**REVIEW OF SIDRA MODEL AND ROAD SAFETY AUDIT
ORICA SOUTHLANDS WAREHOUSE ESTATE
28 MCPHERSON STREET, BANKSMEADOW**

Thank you for referring the abovementioned application which was referred to Transport for NSW (TfNSW) for comment. TfNSW has reviewed the submitted information and provides the following comments for the Department's consideration:

Figure 25: Location of modelled intersections (Source: TRAFFIX)

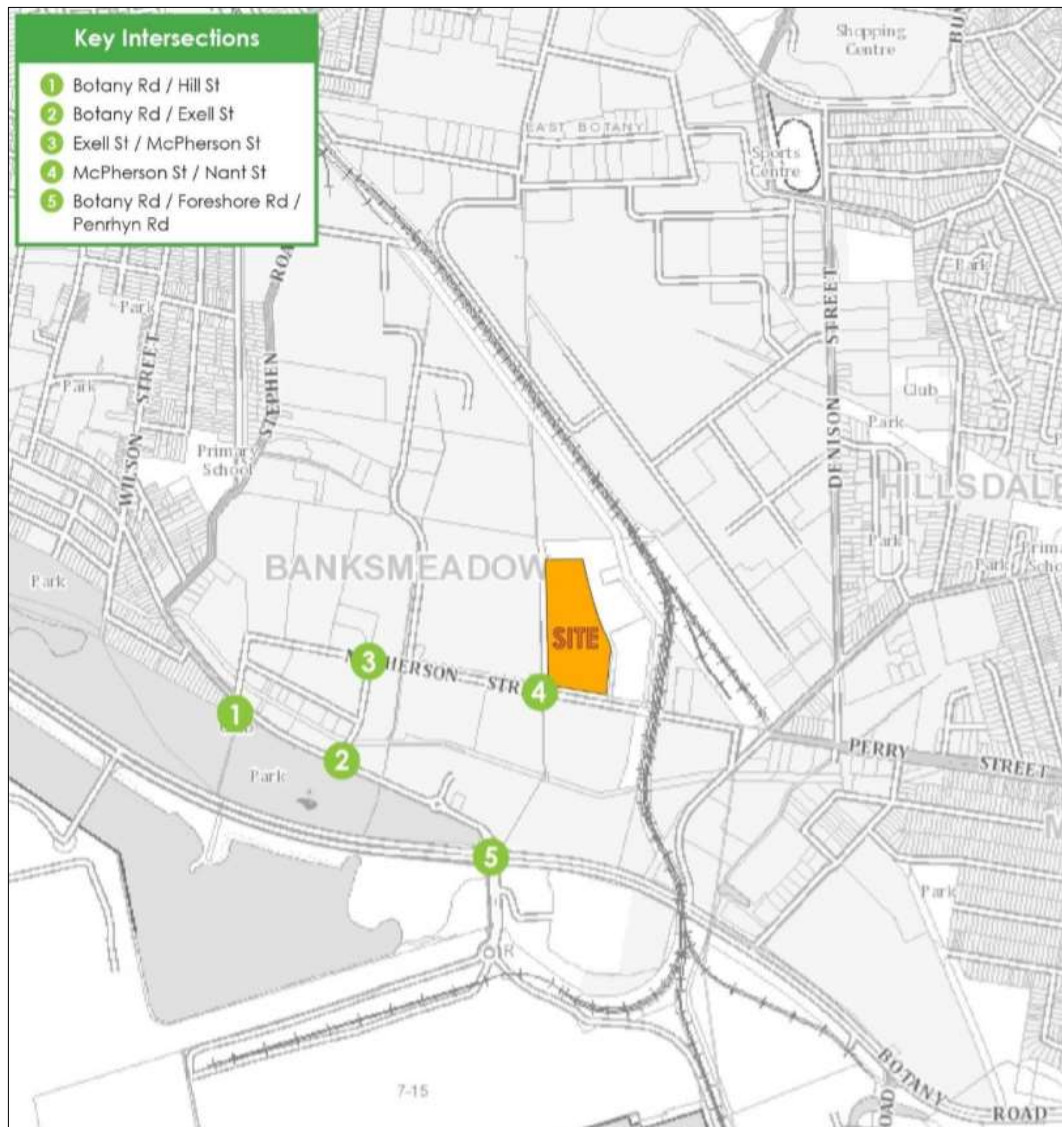
Traffic generation from the development site will be concentrated at the intersection of Exell Street and Botany Road. Exell Street, on approach to Botany Road, currently experiences high delays and long queue lengths during peak times. However, this delay is not reflected in the proponent's SIDRA analysis, where it was shown that delay does not exceed 12 sec/vehicle that is Level of Service (LoS) A / free flow.

If the default values for critical gap and follow-up headway are used, then queue length for Exell Street is 21 metres, which is similar to the applicant's output per *Table 5: Botany Road and Exell Street intersection performance* of their report. However, if the critical gap value is increased from 5 seconds (default value) to 8 seconds (highest value per AGRD 4A) and the follow-up headway is increased from 3 seconds (default value) to 5 seconds (highest value per AGRD 4A), then the queue length in Exell Street increases dramatically from 21 metres to 561 metres, and the average delay increases from 13.2 sec/vehicle (LoS B) to 475.6 sec/vehicle (LoS F).

In summary, the values for critical gap and follow-up headway used by the proponent in the base model have not been adjusted, and hence the queue length and delay reported is incongruent with actual site observations. The intersection of Botany Street and Exell Street is already saturated, meaning that the expected 28% increase in trips to this intersection would have a noticeably negative impact not only on the proposed development operations but also on other road users accessing Exell Street and McPherson Street.

As the expected 28% increase in trips to Botany Street and Exell Street, which is already underperforming will further impact both the local and classified road networks, surrounding sites and the proposed development's operations. Therefore, TfNSW recommends that the site is conditioned to undertaking road works in the form of creating a zipper merge eastbound along Botany Road to end approximately 100 metres east of Exell Street. Specifically:

- To cater for heavy vehicle swept paths, use of the pavement on the southern side of Botany Road is necessary, as well as removal of parking from opposite Exell Street 100 metres to the east. Lane widths are to be a minimum of 3.5 metres; and
- Provision of a separator between the left turn out of Exell Street and the through eastbound lane from the triangular island east for 60 metres. The feasibility of the concept needs to be investigated in accordance with relevant documents, Australian Standards, Austroads' *Road Design and Traffic Management Guidelines*.
